**Rezoning Transportation Analysis**  
**Petition Number: Insert Zoning Petition #2021-056**  
*General Location Identifier: 04105416*

**Revision Log:**

Date	Description
05-27-2021	First Review (EL)
08-24-2021	Second Review (BB)
09-24-2021	Third Review (BB)

The site is located on a City-maintained local road (B Avenue), east of Beatties Ford Road, a City-maintained major thoroughfare. There is unmaintained right-of-way adjacent to the site where a new public roadway (C Avenue) will be constructed. Site plan revisions are needed to meet ordinance requirements and the outstanding items including, but not limited to dedicating public right of way and constructing improvements for new public streets, implementing sidewalk and accessible ramps, and adding standard CDOT conditional notes. Further details are listed below.

Drawing No. **RZ-1.0**

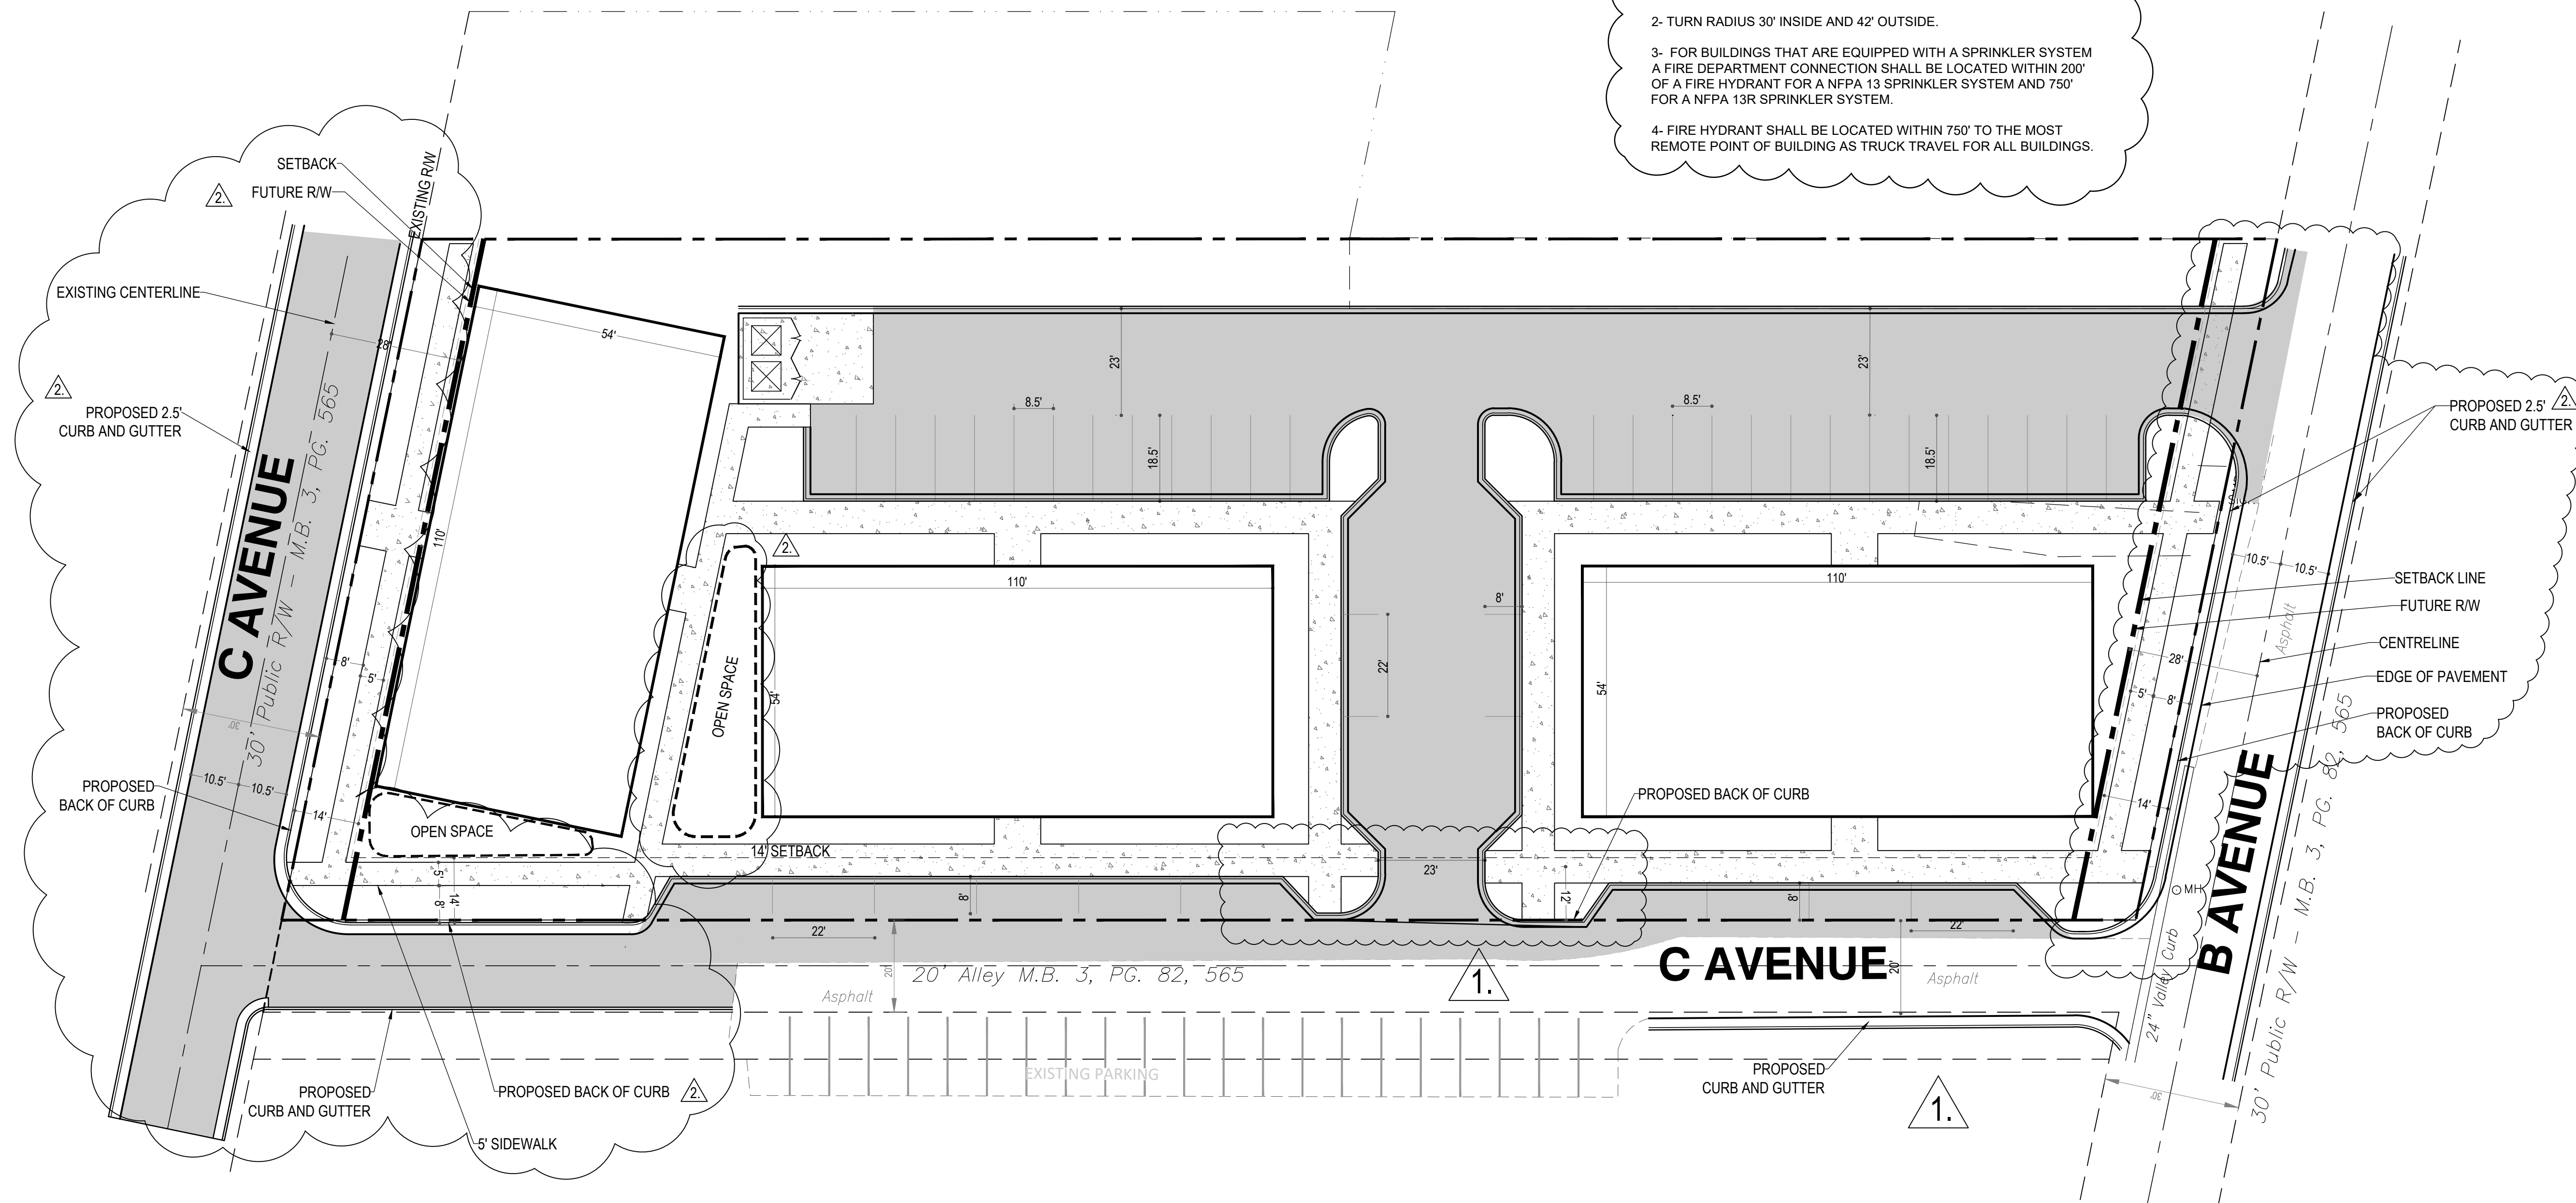
**Outstanding Comment: New Comment as a Result of 08-16-2021 Site Plan:** Planting strip and sidewalk is only required along this rezoning site's property frontage. This planting strip and sidewalk needs to be shown along C Avenue on rezoning sheet RZ-1.0. 8-foot planting strip and 8-foot sidewalk is only required along this rezoning site's property frontage since DUA is greater than 12.

- c. **Outstanding Comment: Alleyway/Paper Right of Way:** Construct a CLDSM standard detail number U-03 – *Local Residential Wide Street Typical Section* (for the portion highlighted in blue) along the property frontage of alleyway/paper right of way. 8-foot planting strip and 8-foot sidewalk is only required along this rezoning site's property frontage since DUA is greater than 12.

Label and dimension the curb and gutter and proposed right of way from the centerline for each road on the site plan.

- Outstanding Comment:** Revise site plan and conditional note(s) to commit to dedicate 35.5-feet of public right-of-way from the alleyway centerline, if public right of way is already platted. The site plan shall label and dimension the right-of-way from the road centerline, per CLDSM standard detail number U-03 – *Local Residential Wide Street Typical Section*. If this is confirmed to only be a 20-foot wide alleyway, coordinate with CDOT to determine the appropriate requirements.

- Outstanding Comment:** Revise site plan and conditional note(s) to commit to construct an 8-foot planting strip and 8-foot sidewalk on all public street frontages per Chapter 19 / Chapter 20 of the City Code and the Charlotte WALKS Council-adopted policy. 8-foot sidewalk is needed since more than 12 dwelling units per acre is proposed. The site plan shall label and dimension both items from the back of curb and gutter and road centerline.

- 6. **Outstanding Comment:** Revise site plan and conditional note(s), including Site Plan Conditional Note 3.a, Access, Transportation, and Improvements to extend the Residential Wide typical section on the alleyway / paper right of way to North Avenue (now labeled as C Avenue).

- 7. **Outstanding Comment:** Revise site plan and conditional note(s) to commit to construct two PROWAG ramps at the alleyway / paper right of way intersections with North Avenue (now labeled C Avenue) and B Avenue.

- 8. **Outstanding Comment:** A site plan note(s) specifying dedication and fee simple conveyance of all rights-of-way to the City before the site's first building certificate of occupancy is issued is needed. CDOT requests rights-of-way set at 2' behind back of sidewalk where feasible.
